DEVIATION REQUEST

Project Name : Meadow Lake Industrial Park

A deviation from the standards of or in Section 2.2.5.B.1 of the Engineering Criteria Manual (ECM) is requested.

Figure 2
Site
Plan

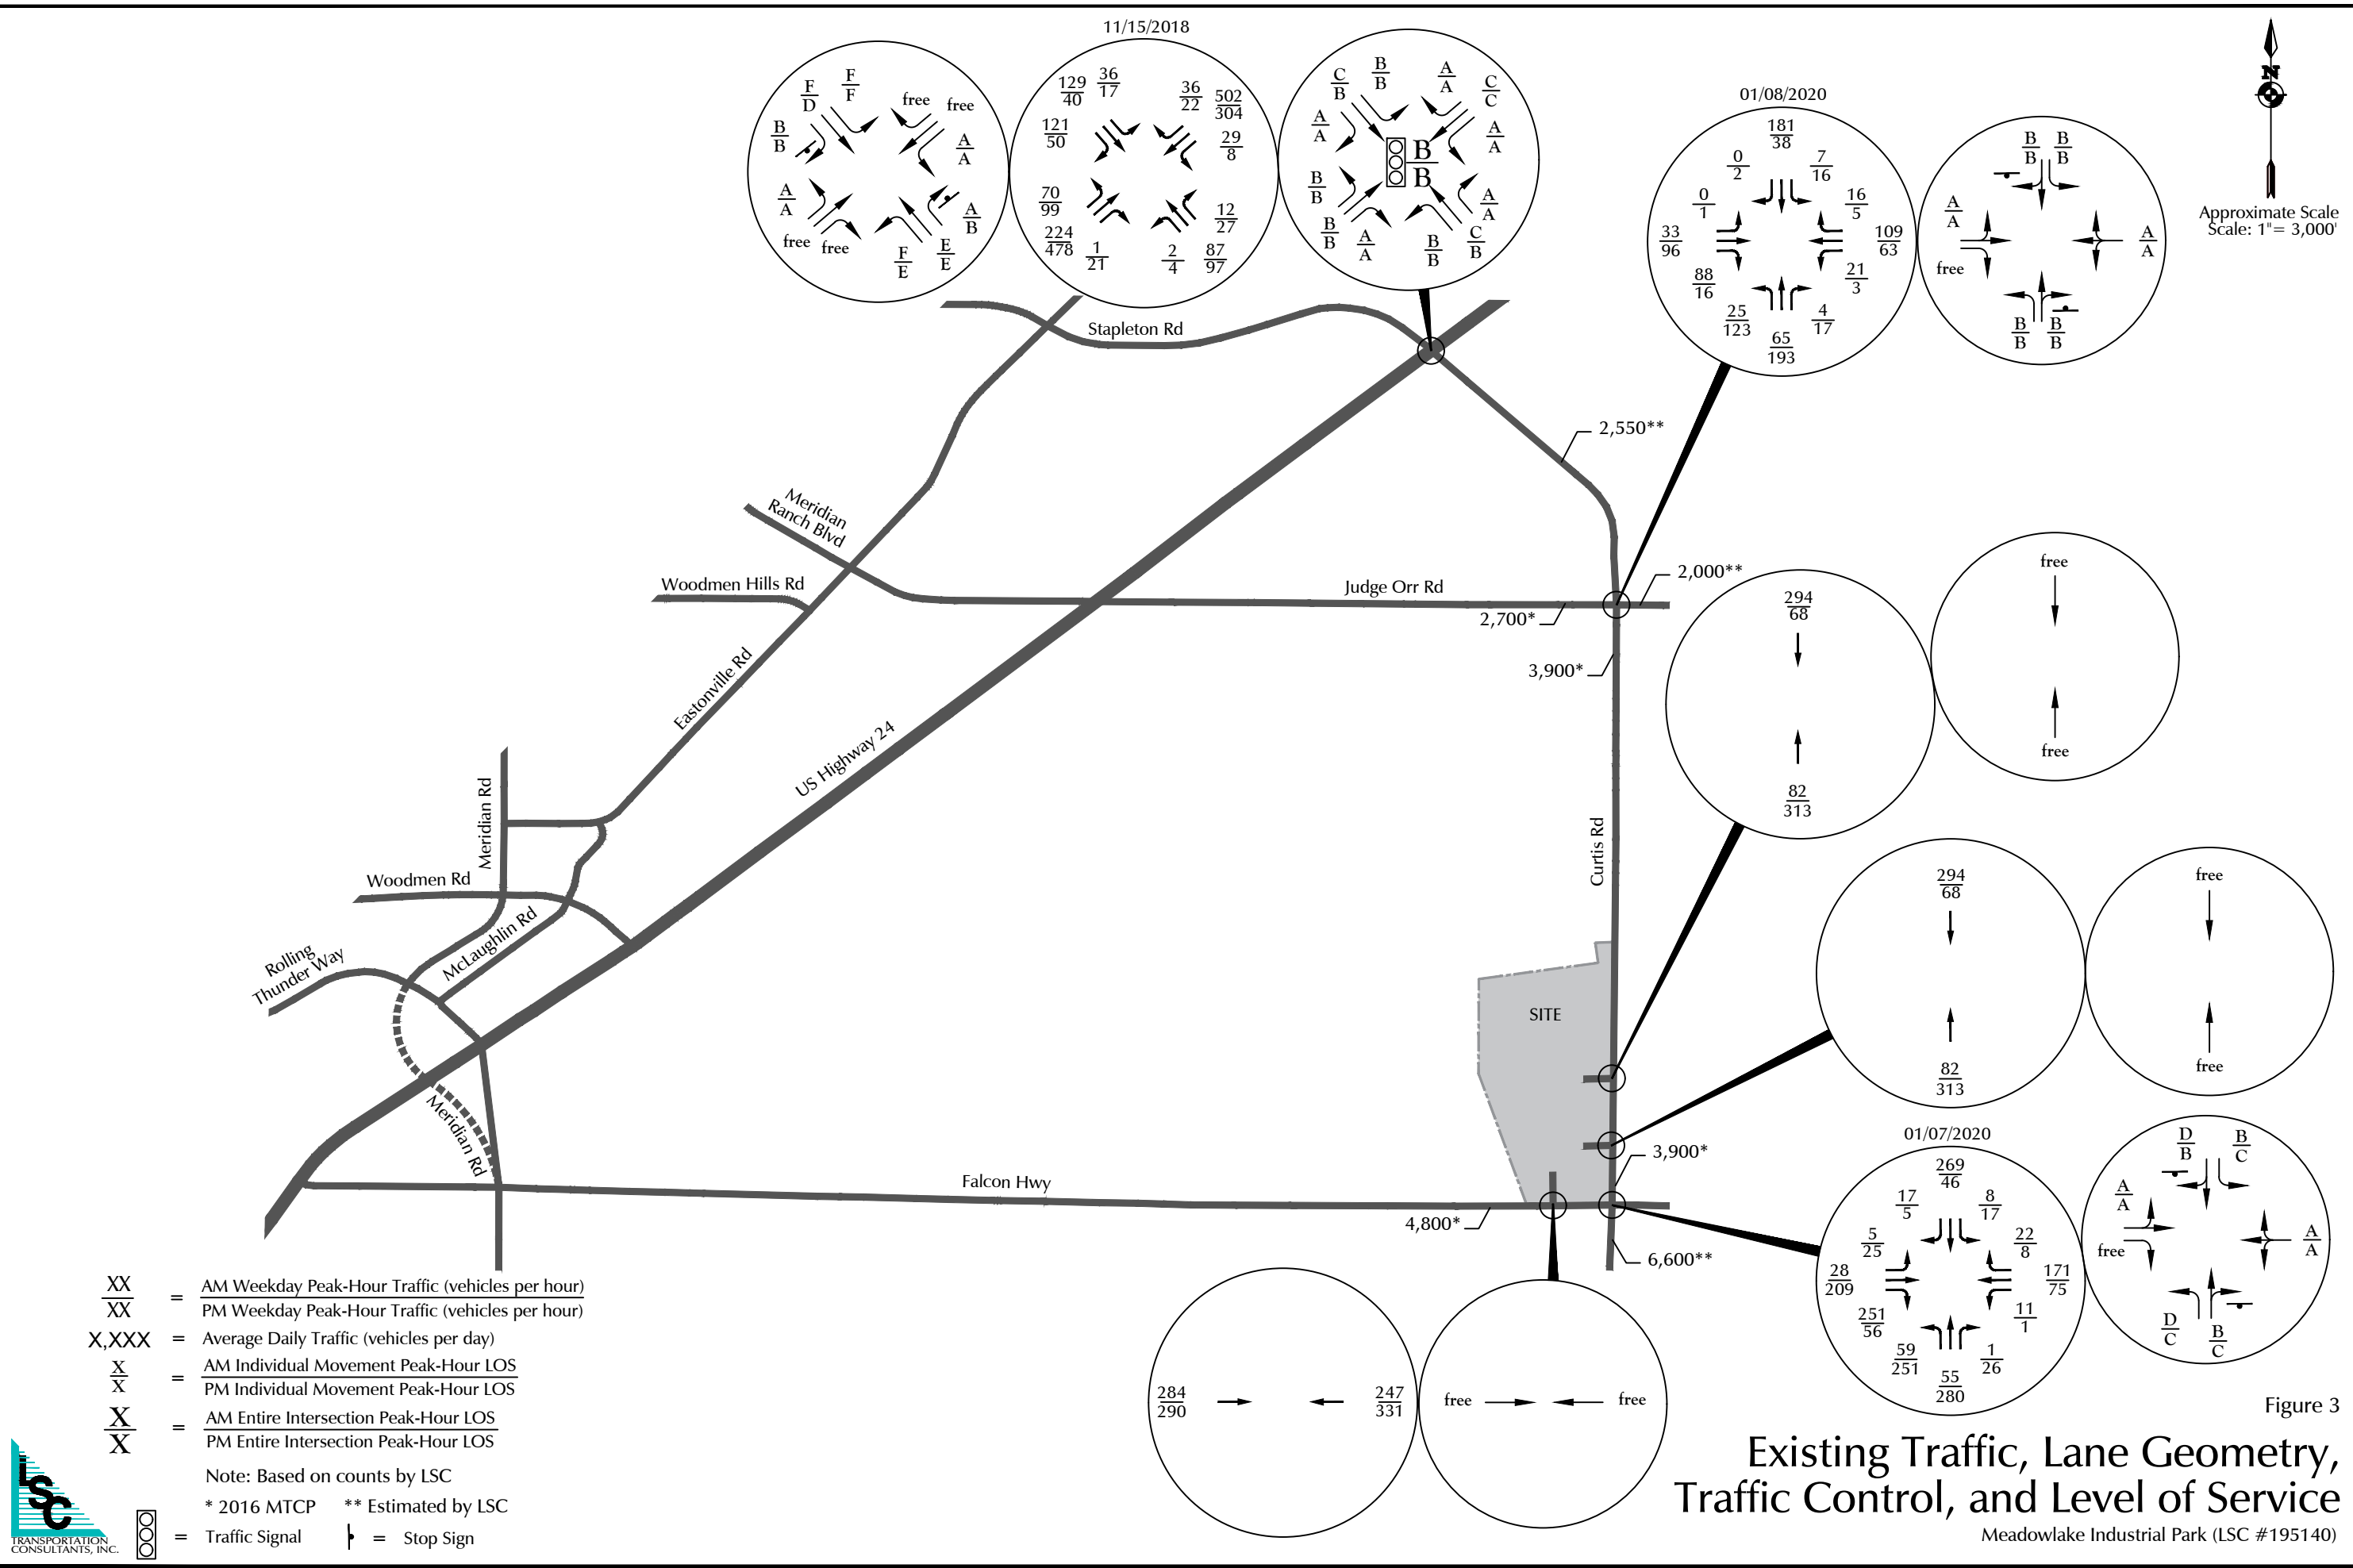
The applicant is requesting approval of a planned public street connection to the west side of Curtis Road ¼ mile north of Falcon Highway. The request is for an interim full movement intersection with Falcon Highway, but the intersection would likely need to be converted to three-quarter movement (or possibly right-in/right-out or right-in only) configuration in the longer term future when Curtis Road becomes a four-lane Principal Arterial as indicated on the MTCP Corridor Preservation Plan. The TIS indicates potential use of a channelized T configuration with the interim full-movement. Please refer to the attached exhibit (Figure 2 from the TIS report).

The proposed alternative is for an interim full movement access to the west side of Curtis Road ¼ mile north of Falcon Highway. The access would likely need to be converted to three-quarter movement (or possibly right-in/right-out) in the distant future when Curtis Road becomes a four-lane Principal Arterial as indicated on the MTCP Corridor Preservation Plan.

The spacing would be 1,300 feet shorter than the ECM standard for Principal Arterials. The ECM only shows criteria for a four lane Principal Arterial. The proposed ¼ mile spacing would be consistent with the spacing of intersections for a Rural Minor Arterial. The rationale is that the Curtis Road two-lane Principal Arterial would more closely resemble a Rural Minor Arterial. Note: this intersection spacing was approved as part of the 2013 ZCP Plan.

The deviation request has been provided to the ECM administrator for review and a decision. The deviation requests for the intersection spacing would not be a part of this rezone as the actual design layout for the roadways have not been submitted and so that a decision on the deviation does not hold up the rezone project. You will be informed once a decision has been made.
